**City of Portland, Maine - Building or Use Permit Application**

Permit No: 02-1377  
 Issue Date: DEC 16 2002  
 CBL: 171A B013001

**Proposed Project Description:**  
17 x 35 inground swimming pool with patio and fence to surround

Department: Building  Status: Approved with Conditions Reviewer: Jeanine Bourke

THE NEALE RESIDENCE
SITE GRADING & UTILITIES
AUDEN'S WALK - PORTLAND, ME.

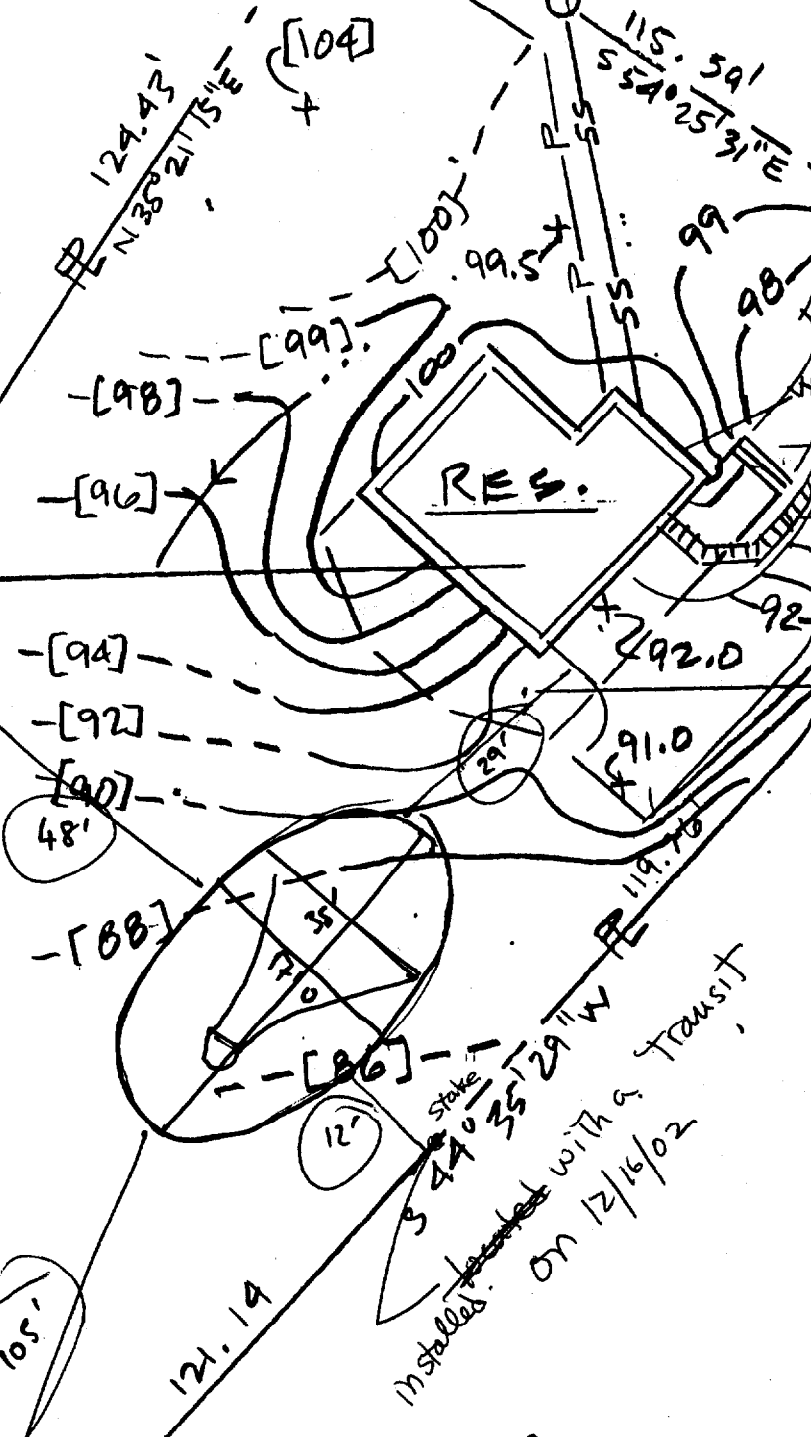
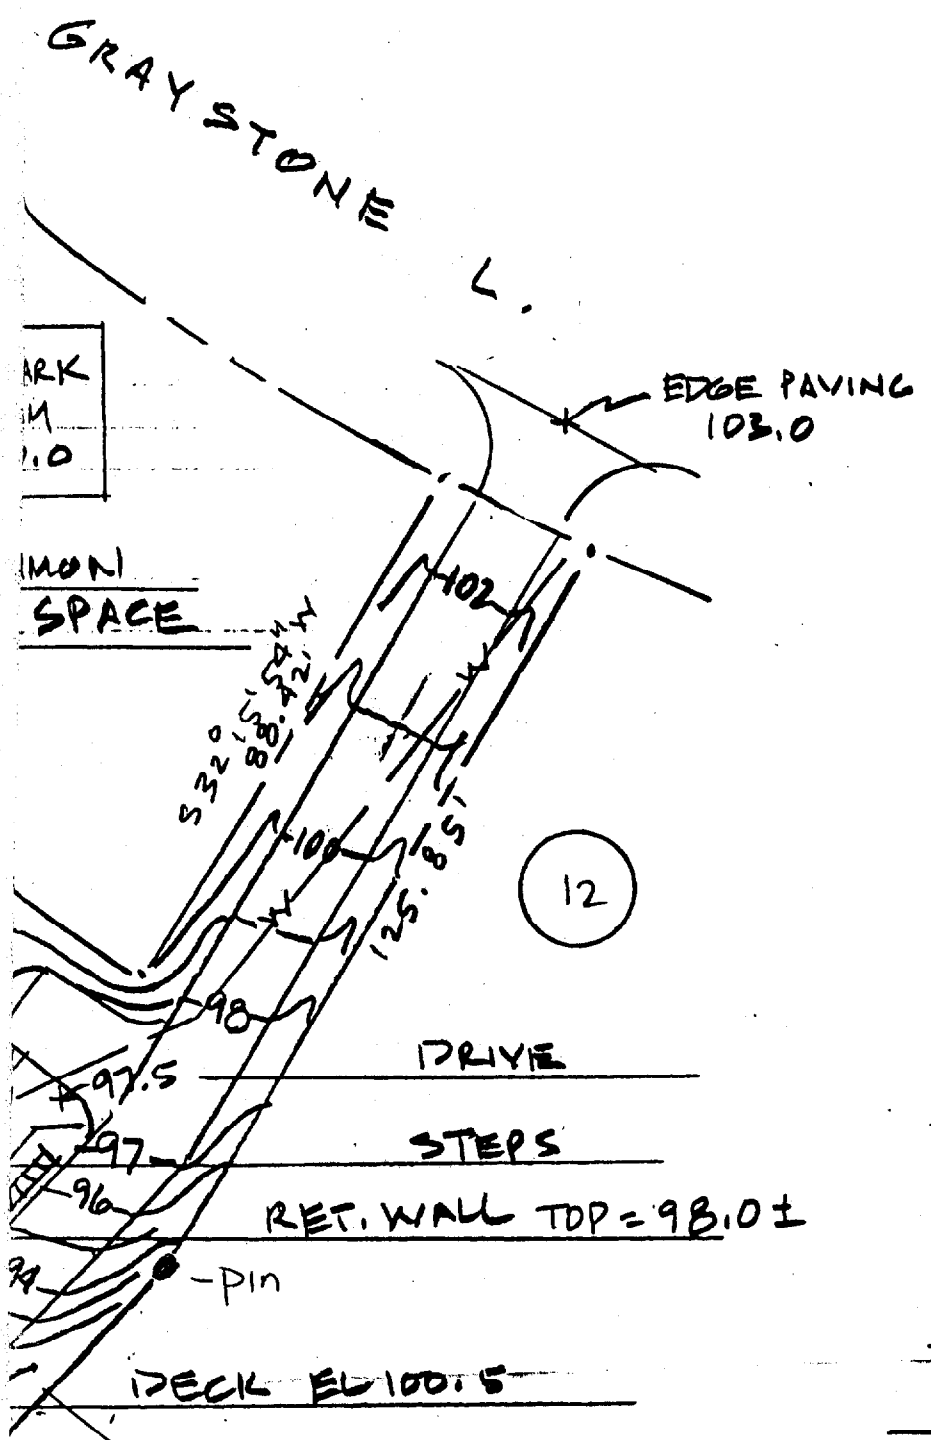
Setbacks to the pool structure shall be a minimum of 10' to all property lines and dwelling
